**KIRKLEES COUNCIL
TOWN AND COUNTRY PLANNING ACT 1990
HIGHWAYS DEVELOPMENT MANAGEMENT**

PLANNING REF 2017/62/91047/E0/ET
CATEGORY Minor

PROPOSAL PART DEMOLITION OF FIRE
STATION AND ERECTION OF 4 NO
WAREHOUSE UNITS AND 4 NO
APARTMENTS

LOCATION FORMER FIRE STATION
HUDDERSFIELD ROAD
SCOUT HILL
DEWSBURY
WF13 3RN

Proposed parking layout

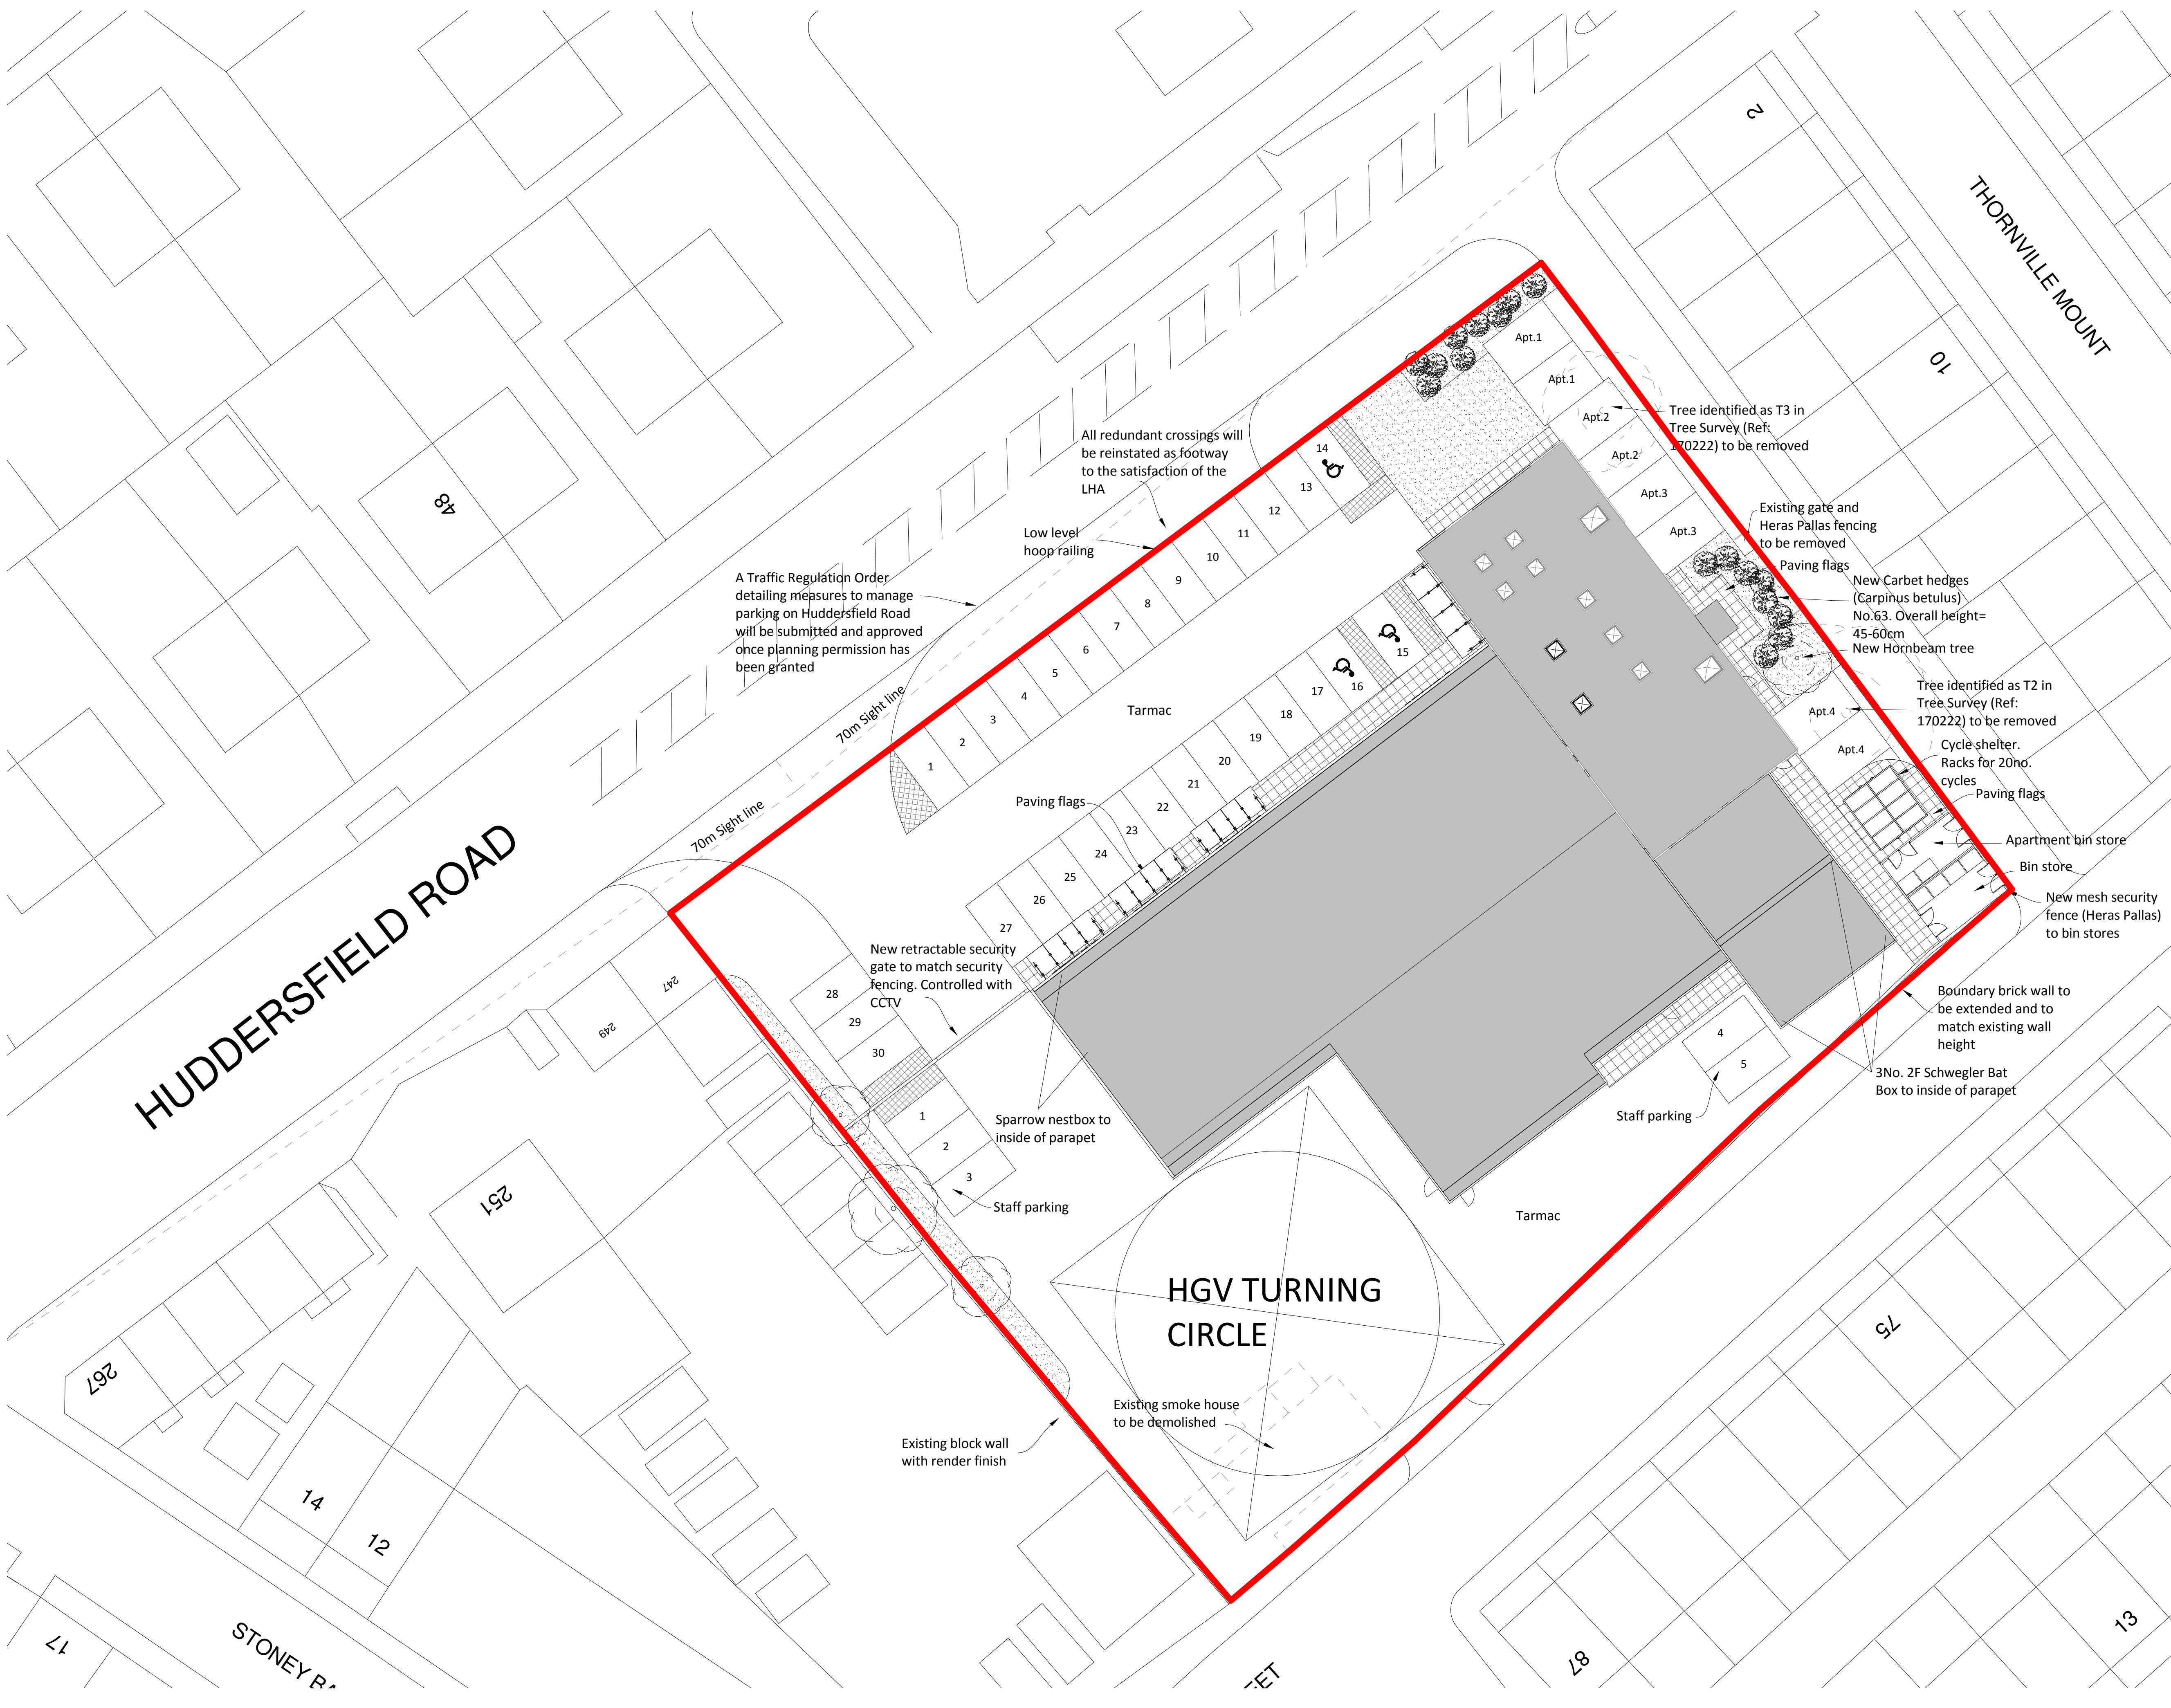
Further to the highways consultation response dated 16th June. The applicants have provided revised plan number GTDE - MWA - XX - XX - DR - A - 0009 rev H which shows

1, internal turning provided for a 16.5 metre articulated vehicle

2, the parking spaces to the proposed apartments have been widened to improve access

3, sightlines from the proposed access shown on the plans

4, redundant footway crossings reinstated as footway

5, a proposal for a scheme detailing measures to manage parking on Huddersfield Road along the development frontage.

These proposals are therefore considered acceptable and Highways have no wish to resist the granting of planning permission.

Before development commences, the sightlines of 2.4m x 70 metres shall be cleared of all obstructions to visibility exceeding 1 m in height and these shall be retained free of any such obstruction.

Prior to the development being brought into use, turning facilities shall be provided in accordance with the details shown on drawing no GTDE - MWA - XX - XX - DR - A -0009 rev H . The turning facilities shall thereafter be made available for use at all times by vehicles and shall be kept free from obstruction to such use.
